## TREE PROTECTION AND PRESERVATION – METHOD STATEMENT

This statement should be read in conjunction with drawing 1578\_307 Tree protection plan.

Comments were made by the Council Tree Officers as part of application reference; 22/01673/AMEND | Non-material amendment to planning permission ref. 21/02772/FUL were it was acknowledged that the applicant has been taking appropriate steps to preserve the Norway maple tree (T01) adjacent to the proposed replacement garage;

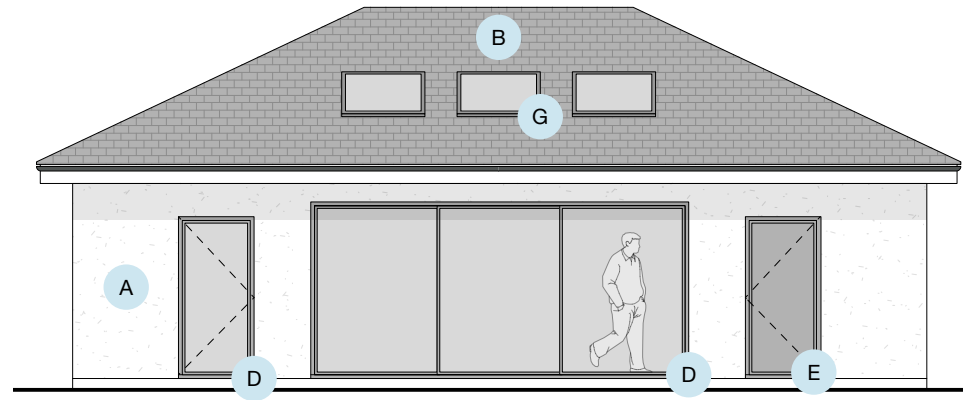
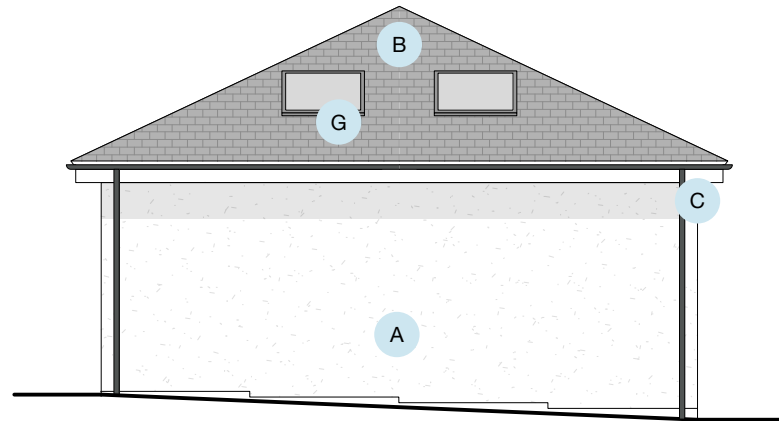
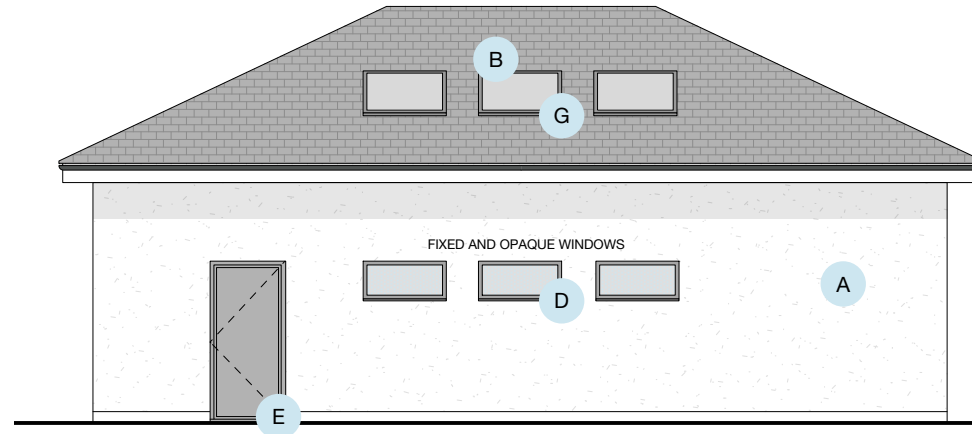
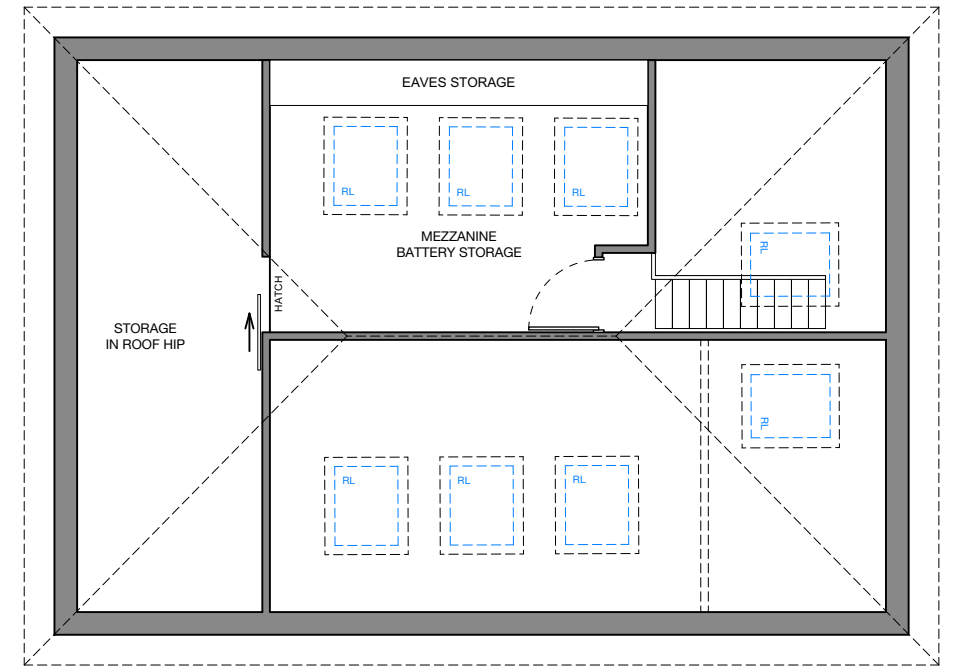
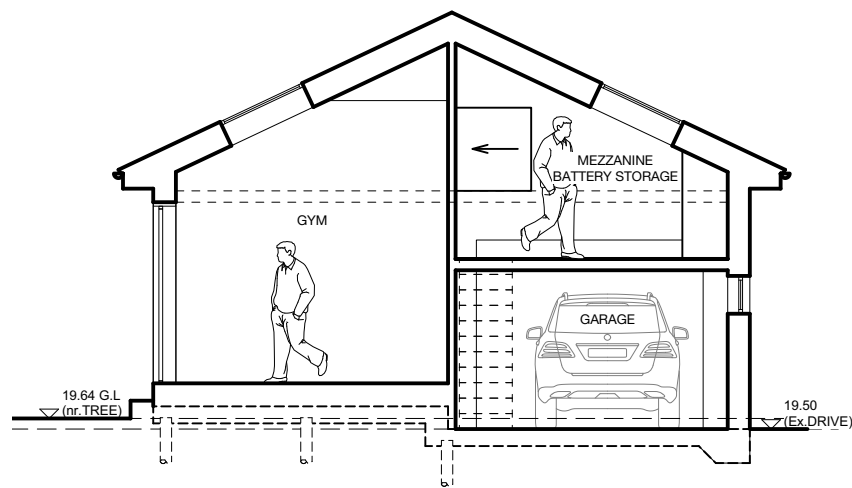
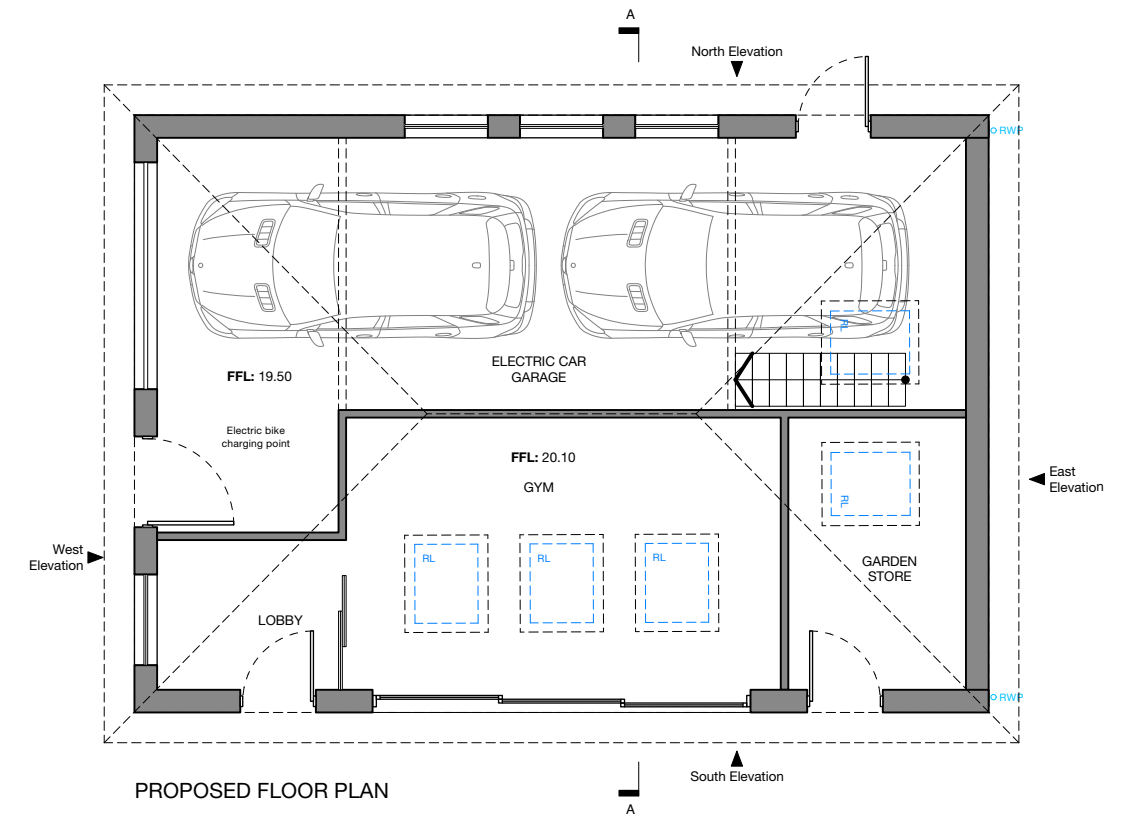
*“The amendments are acceptable to the Trees Section. Although the sky lights could increase pressure to prune the Norway maple (which will cast some shade and drop leaves and debris), the applicant has gone to some lengths to retain this tree in the design of the building. No further details are required by the Trees Section. The gutter cover informative should be used.”*

We have taken this into account and recommend the use of leaf guards (mesh / brushes) be installed to all gutters to minimise the extent of dropped leaves and debris entering the rainwater goods and thereby the need for increased pruning of the Norway maple (T01). The construction of the garage foundation slab has also been designed to minimise the impact of the replacement structure and seeks to safeguard the tree as outlined below in this method statement.

The garage slab has been designed to be 'split' so that the foundation slab is set higher in the gym, lobby and garden store above the existing tree roots and supported on piles. This 'shallow dig' solution shall comprise of a 225mm deep R.C. slab cast over a polythene membrane over 100mm clayboard formers which shall not only provide 'heave' protection to the foundation but also help reduce compaction of the root system. The area of slab further north below the parking area shall be ground bearing so that it sits at the existing driveway level, again this shall be of shallow depth 255mm deep RC concrete laid over an impermeable polythene membrane.
